State Significant Development (SSD 5899) – Brandy Hill Quarry – Hanson Construction Materials Pty Ltd - Environment Protection Authority Comments and Request for Further Information

EPA comments and Further Information Request – Brandy Hill Quarry Expansion Project (SSD 5899) Environmental Impact Statement (EIS) February 2017

Figure 11-1: Proposed Bund Location [Hanson, 2014]

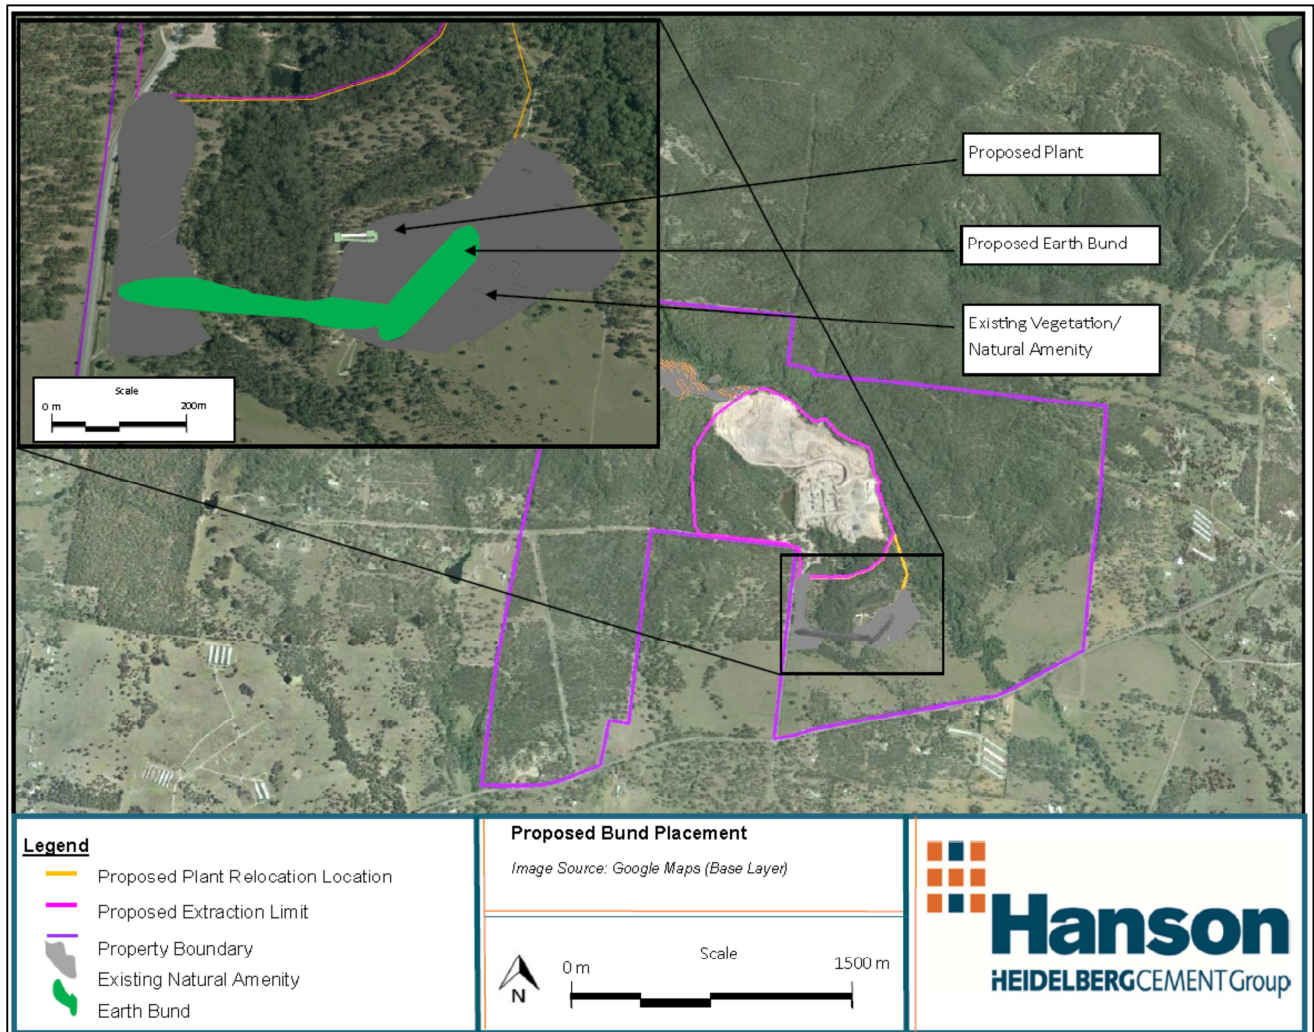
The EIS proposes an 18 metre high “screening bund” to manage visual impacts. Such a bund may also have operational noise benefits, but it is not clear whether it was included in the noise modelling.

- clarify whether the “screening bund” has been included in the noise modelling,
- demonstrate that all feasible and reasonable noise mitigation measures were included in the project’s noise model,
- identify whether there are any other feasible and reasonable noise mitigation measures that the proponent can implement.
